RE: Pitre KIA – Site Plan EPC

CONDITIONS OF APPROVAL-PR-2024-011052, SI-2024-01468 – Major Amendment to Site Plan – EPC

Per the conditions of approval dated November 21st, 2024, please find the following responses addressing the comments listed below:

3/24/2025  
Project NO: 2024-120  
COPYRIGHT MITCHELL ASSOCIATES INC ALL RIGHTS RESERVED  
Drawing No. 1 of 4  
**LS-101**

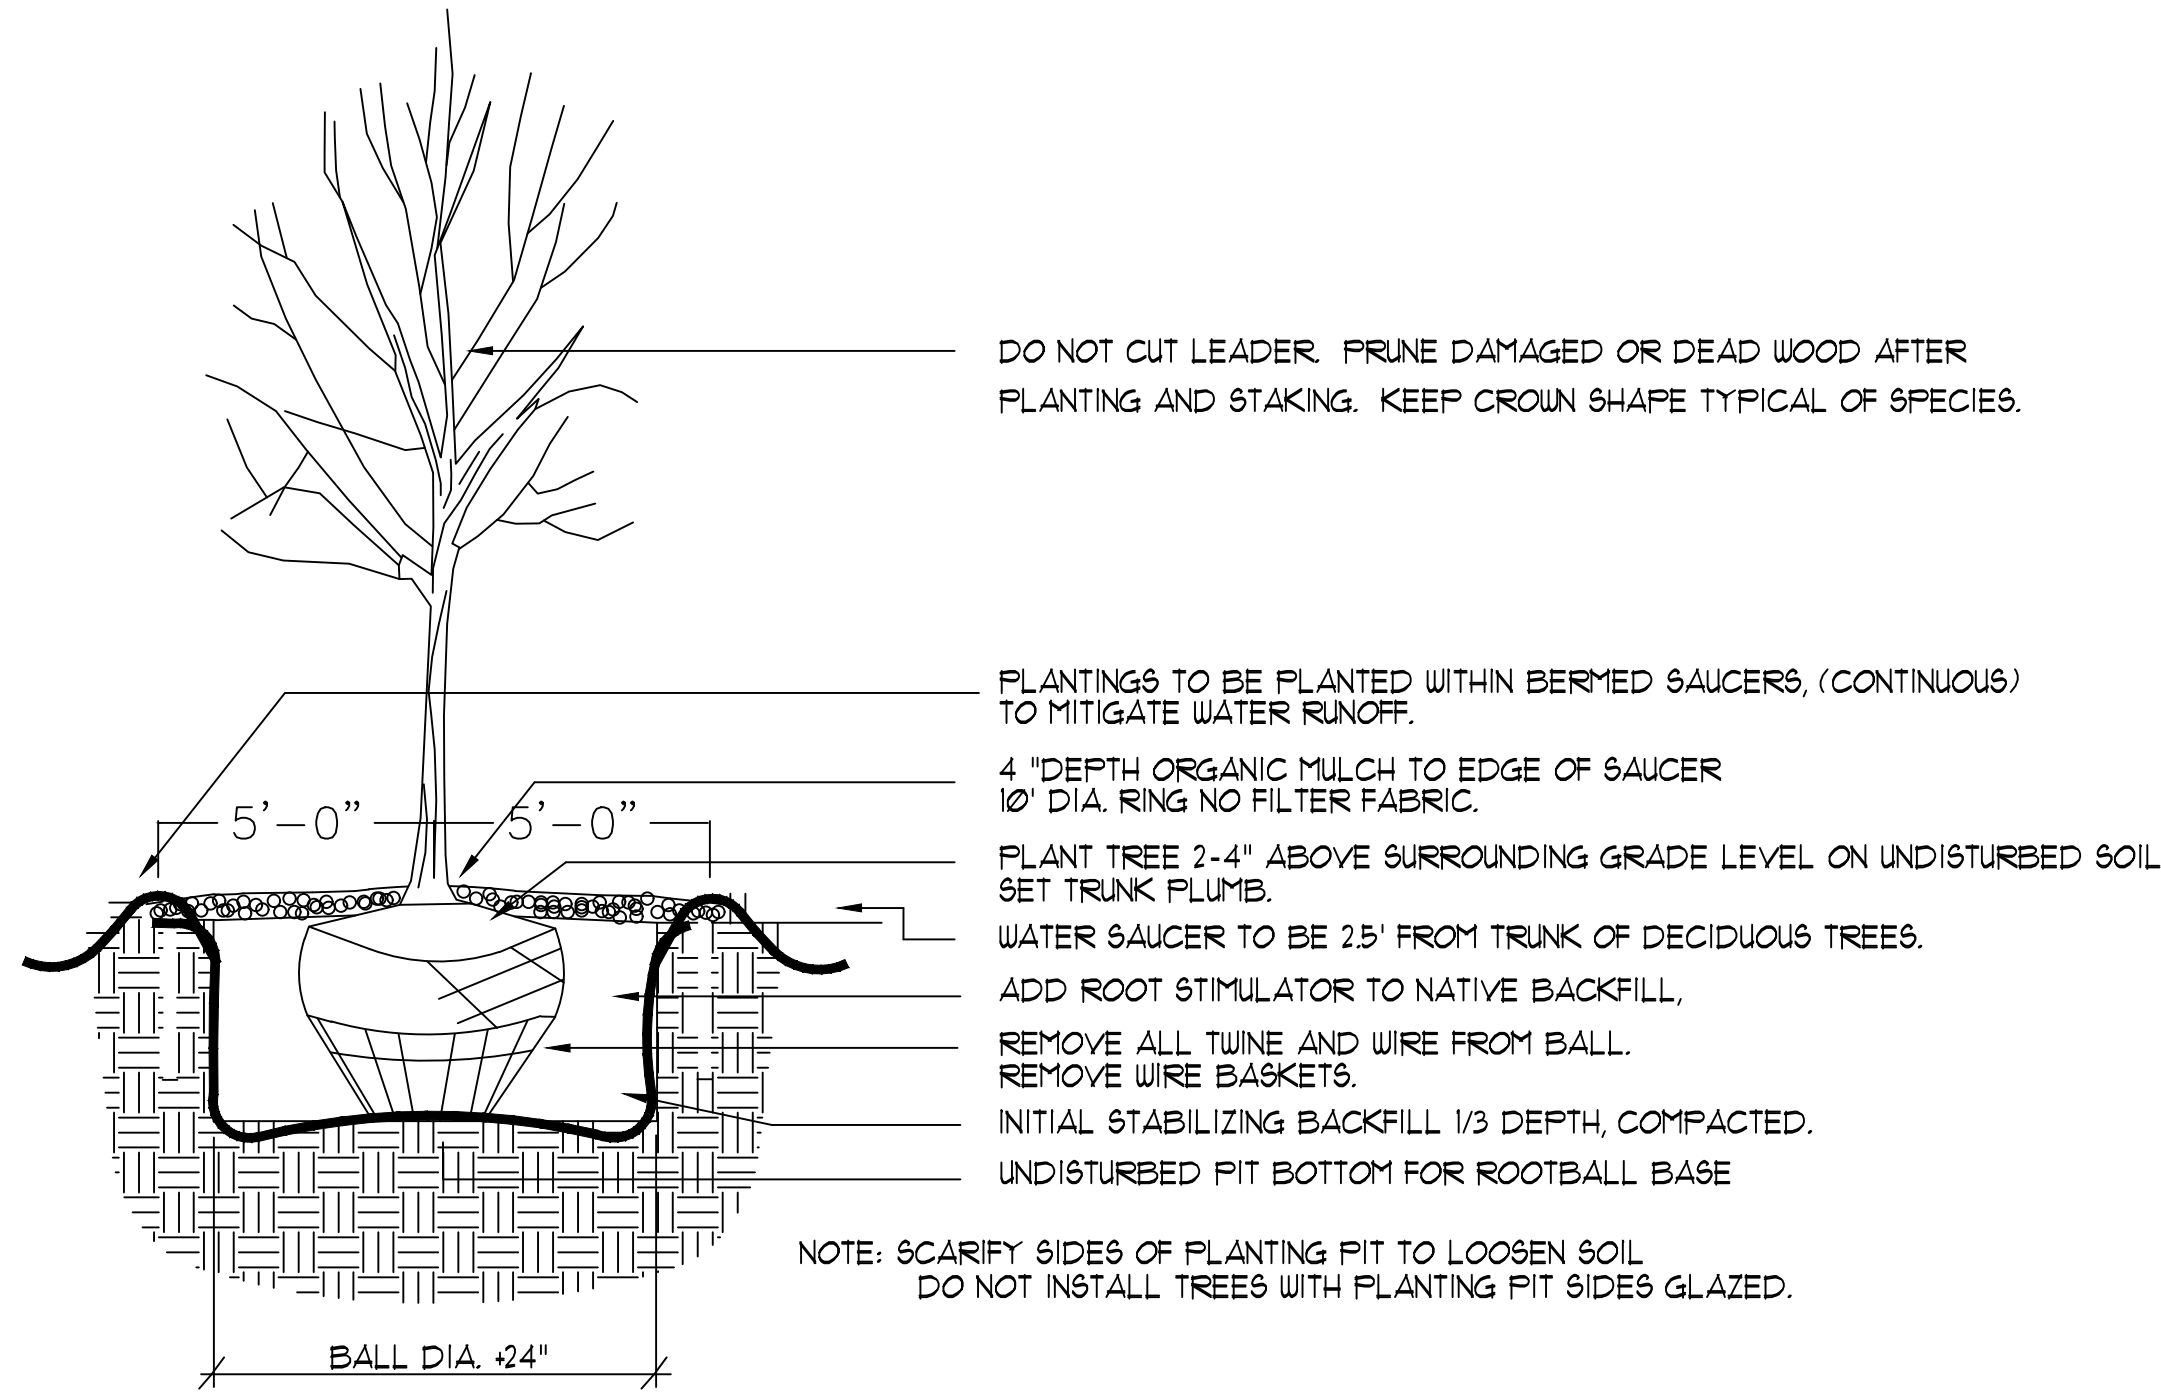
- Landscape Plan shall be stamped and signed by a licensed Landscape Architect.
- Revise the Landscape Plan to clearly show what is existing and what is to remain.
- Per Street Tree Ordinance 6-6-2-4 REQUIRED STREET TREES (1) All applicants for building permits for construction of a new building or building addition of 200 square feet or more shall submit a street tree plan for those parts of the lot abutting a major street, a major local street, or another street where street trees are required.
- Show street trees 25 feet on center along Westside Boulevard.
- Revise the Landscape Plan to select a tree species other than ash trees, which are overplanted and struggling in current climate conditions.
- Work with Urban Forestry to revise the Landscape Plan to identify the shrubs to be replaced and maintained.

A. The asphalt paving limits shall be modified to accurately show the new paving limits around the proposed addition.

B. The new plantings on the southeast corner of the proposed addition shall be identified.

Applicant Response: Updated Landscape Plan stamped and signed by a licensed Landscape Architect is attached to this letter. Plan addressed the various comments iterated above from the CABQ Parks and Rec. Urban Forestry.

Applicant Response: Updated Landscape Plans stamped and signed by a licensed Landscape Architect is attached to this letter. Plan identifies the limits of the new paving around the proposed addition and details the plantings on the southeast corner of addition accordingly.

NORTH ELEVATION  
2/A2.1

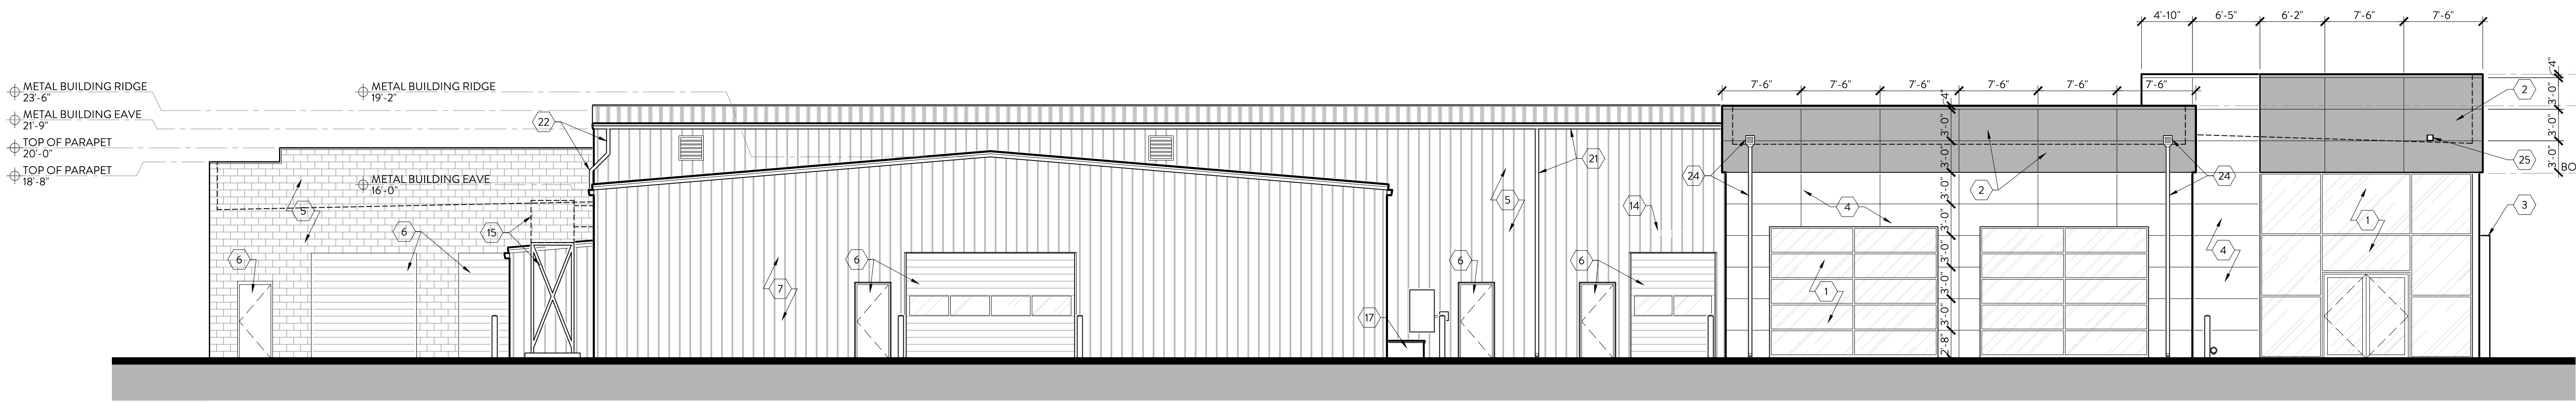
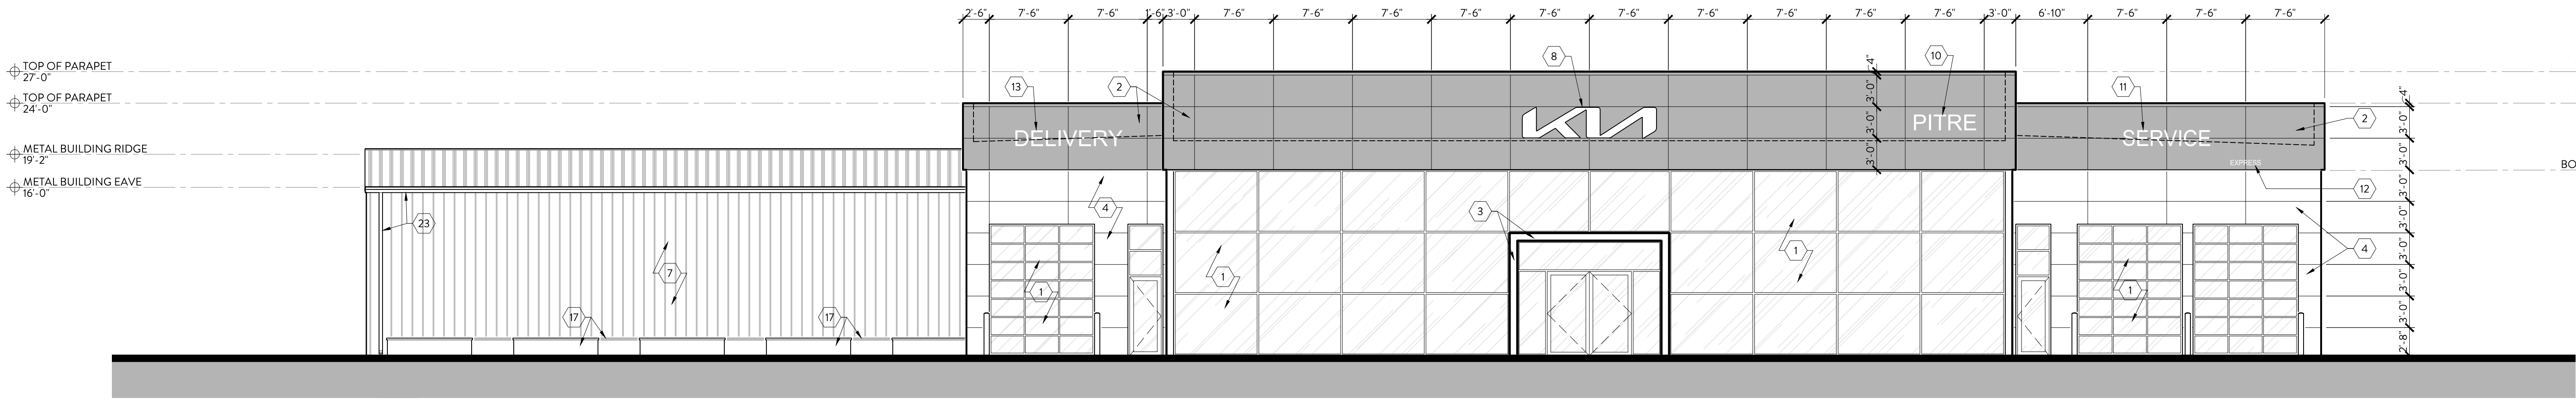
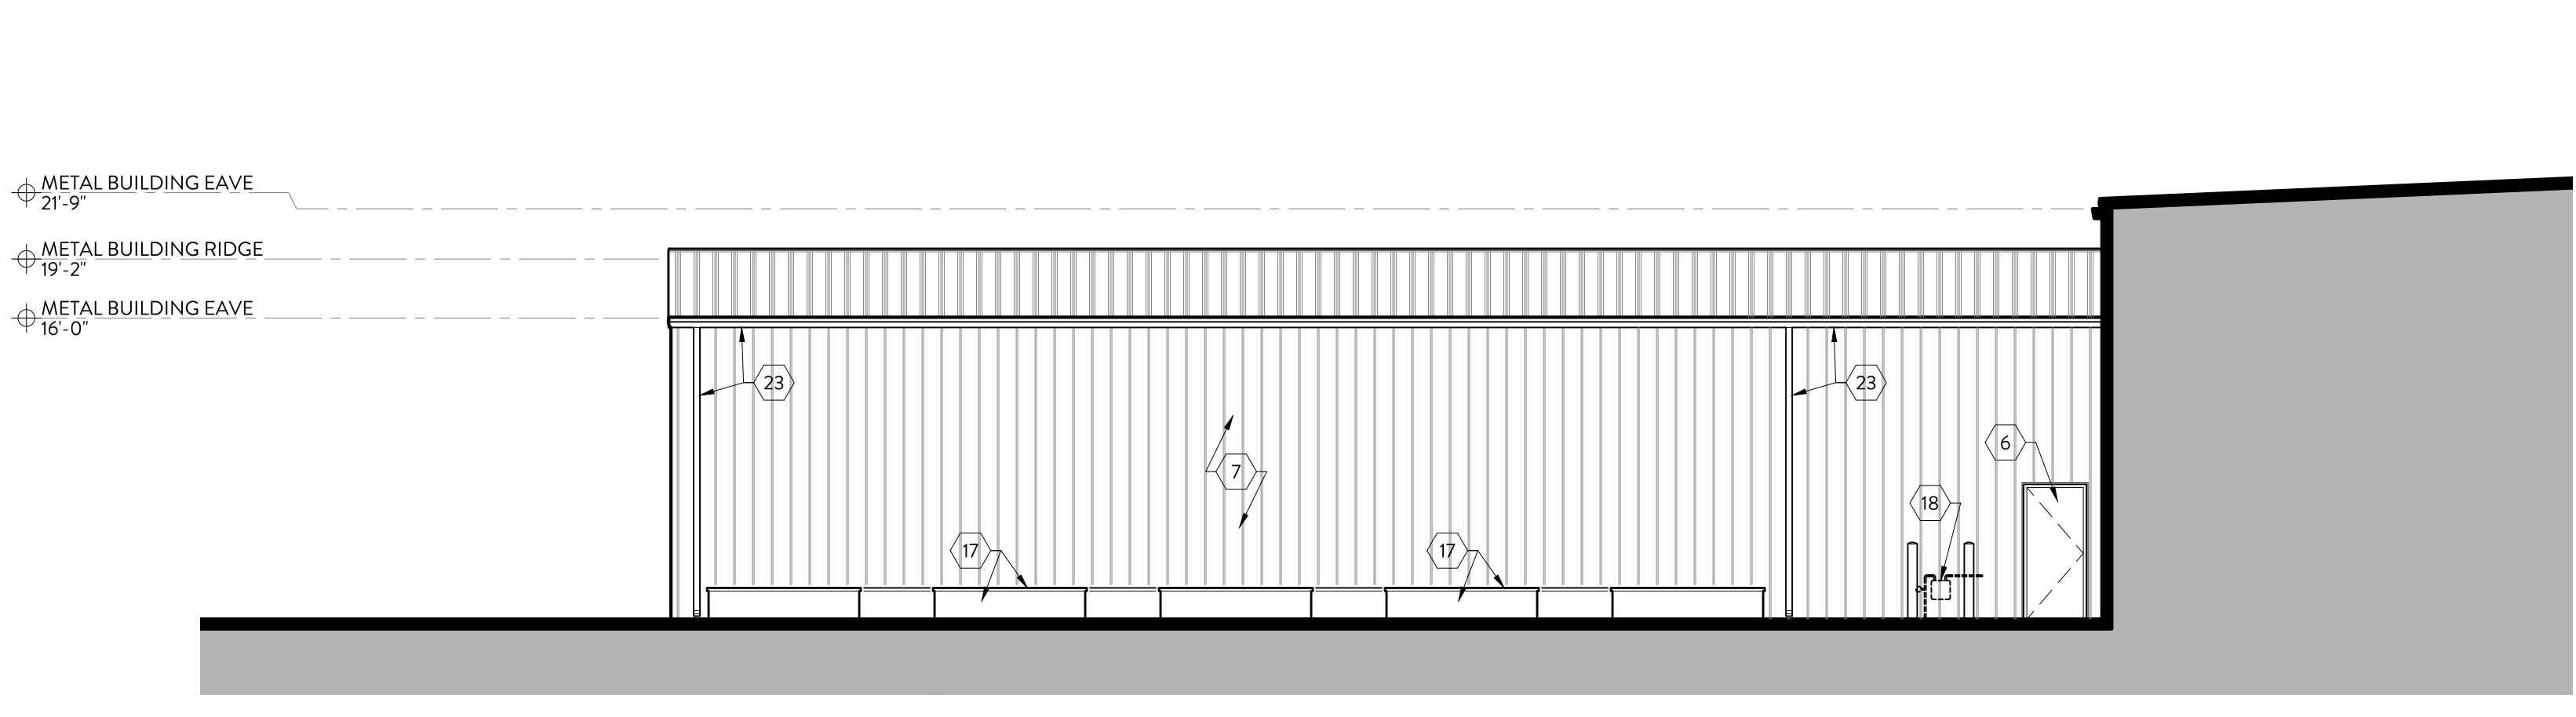
10. Exterior Elevations Sheet:

A. The missing "Parts" sign on the East (Side) Elevation for Keyed Note #14 shall be added to the sheet.

B. The North (Front) Elevation of the proposed addition with the 57'-0" façade shall incorporate 1 required feature every 40'-0" to adhere to the required total of 2 features along 30 percent of the length of the façade pursuant to §14-16-5-11(E)(2)(a)-(g).

Applicant Response: Updated Elevation Sheet is attached to this letter, addressing the comments referenced above.

# E0.1

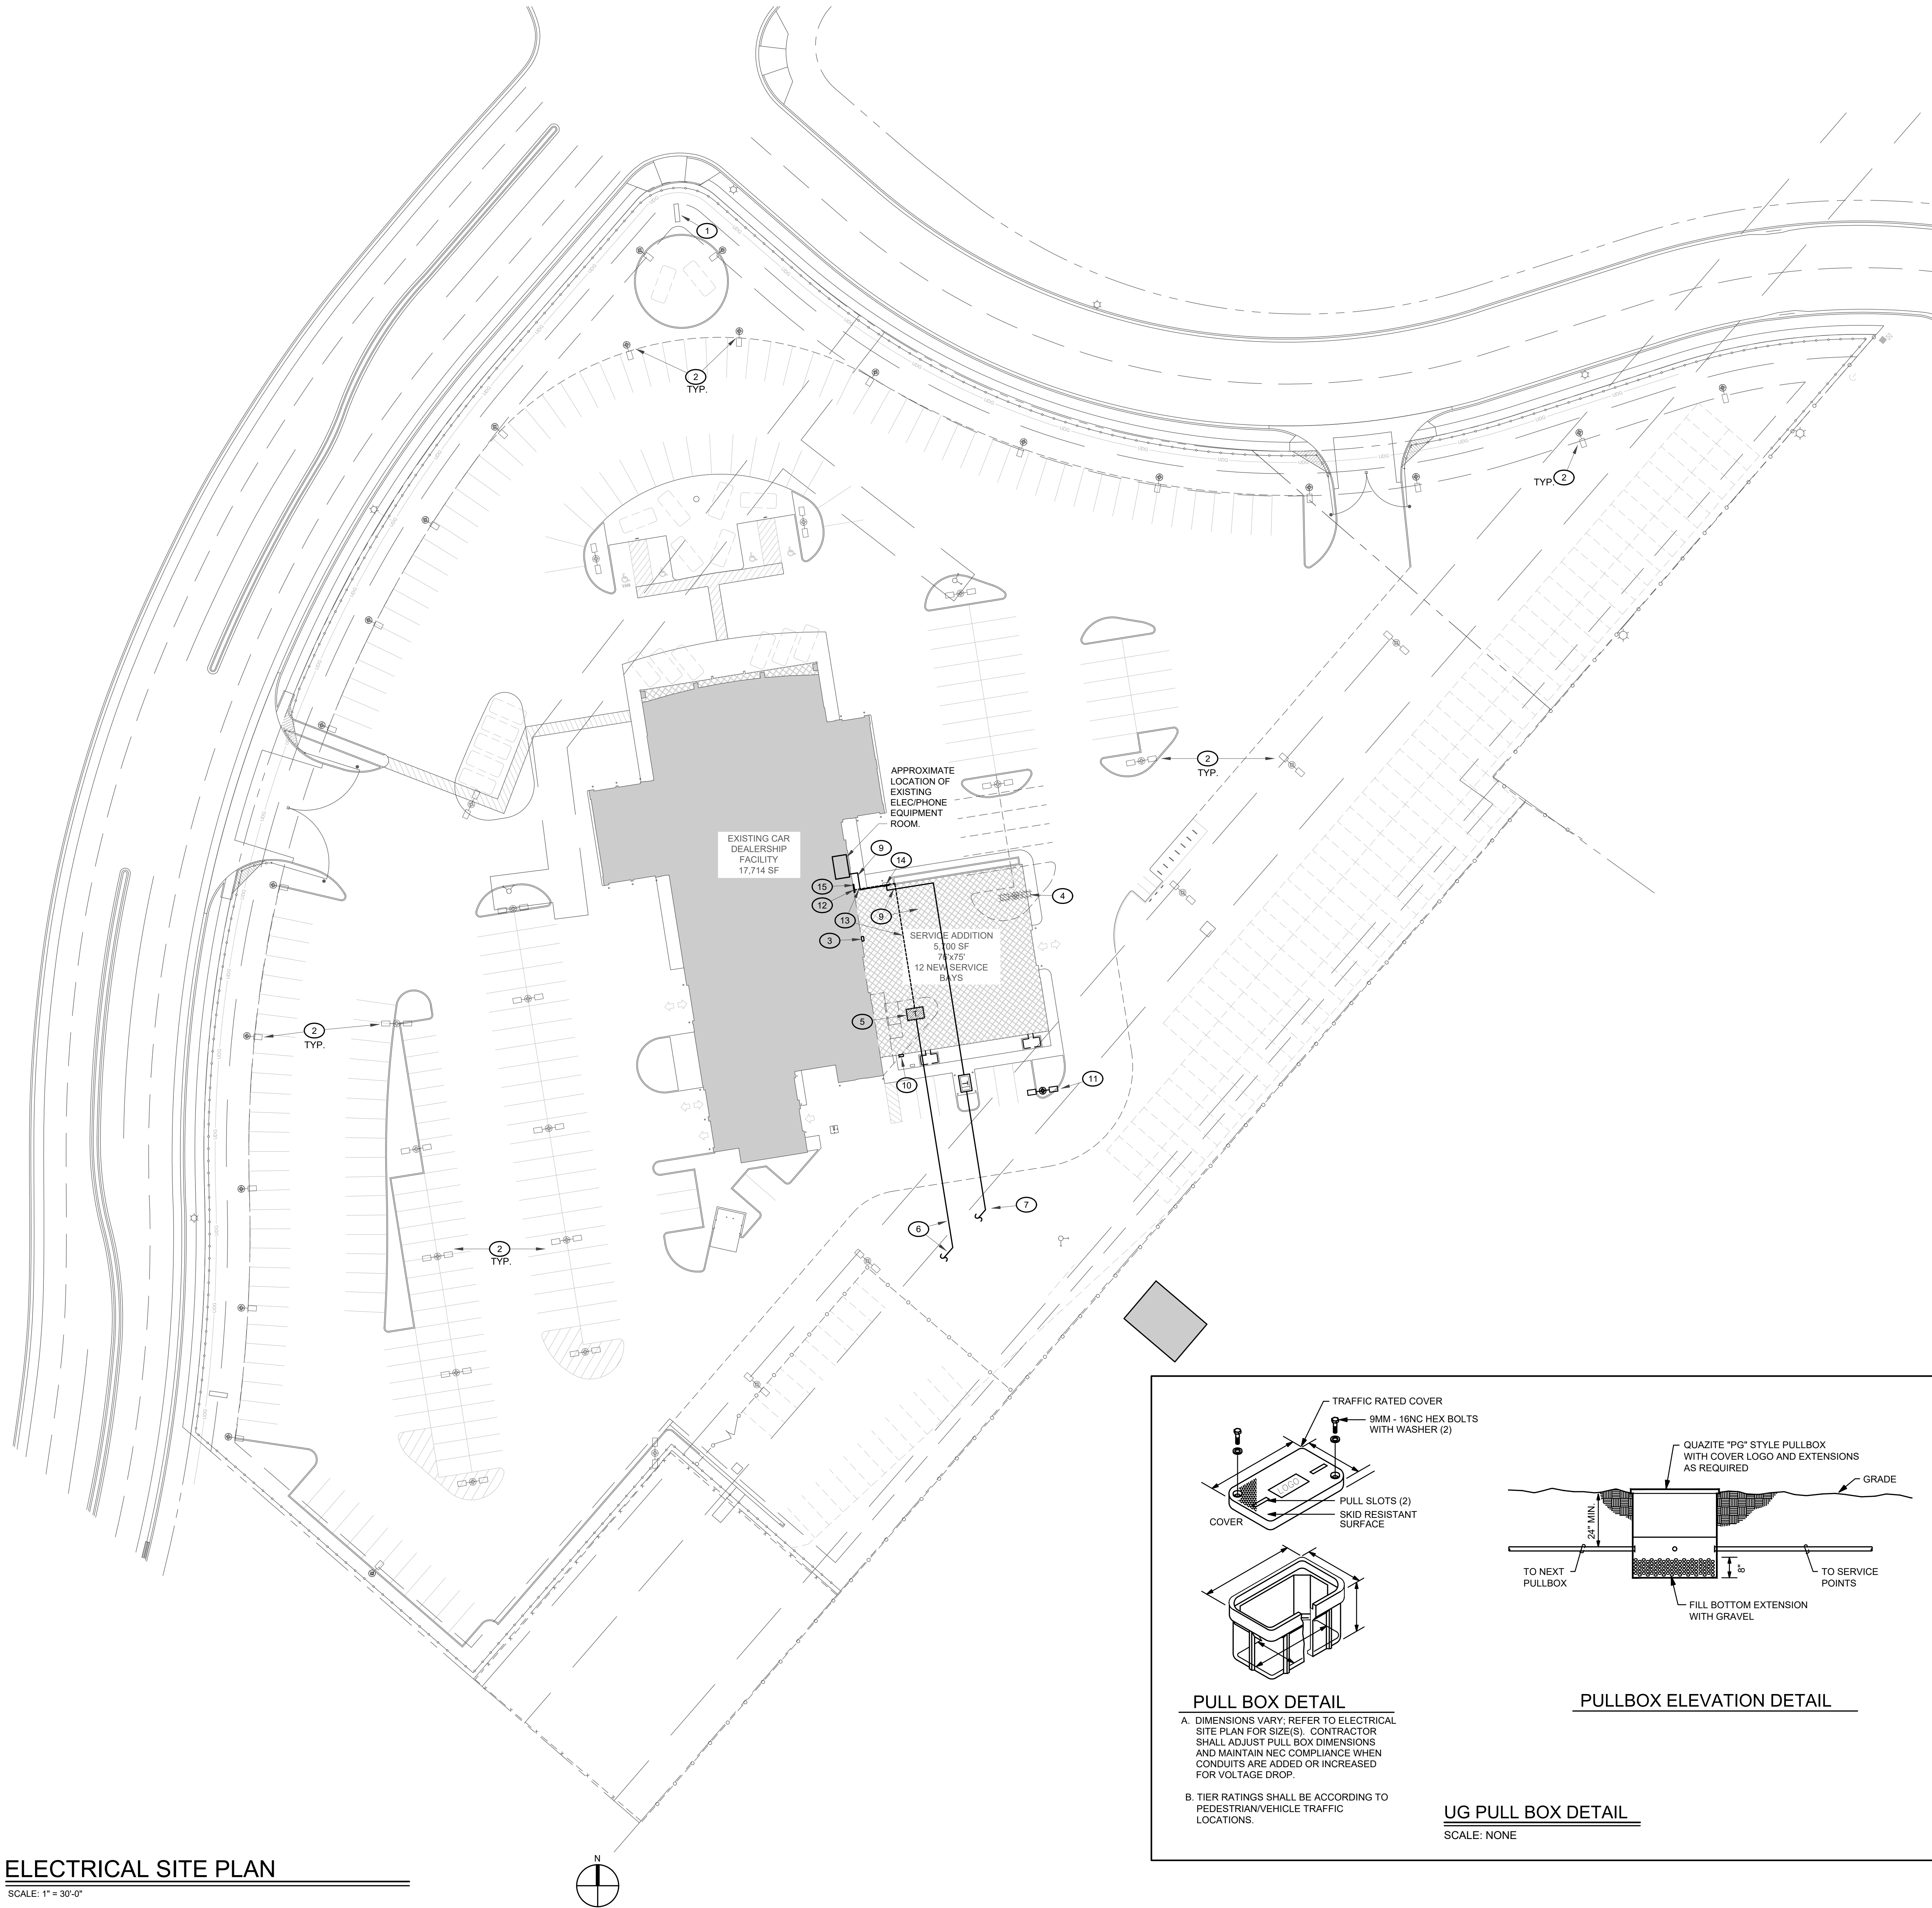
8. The site lighting shall come into compliance with the Outdoor and Site and Light standards of IDO §14-16-5-8 or the applicant shall show how the existing outdoor lighting complies with the IDO. A site lighting plan shall be provided to city staff prior to sign off. If the applicant is unable to comply with IDO §14-16-5-8 they shall return to EPC for an outdoor and site lighting performance analysis.

Applicant Response: Site lighting sheets (E0.1 & ES1.0) in compliance with the IDO are attached to this letter.
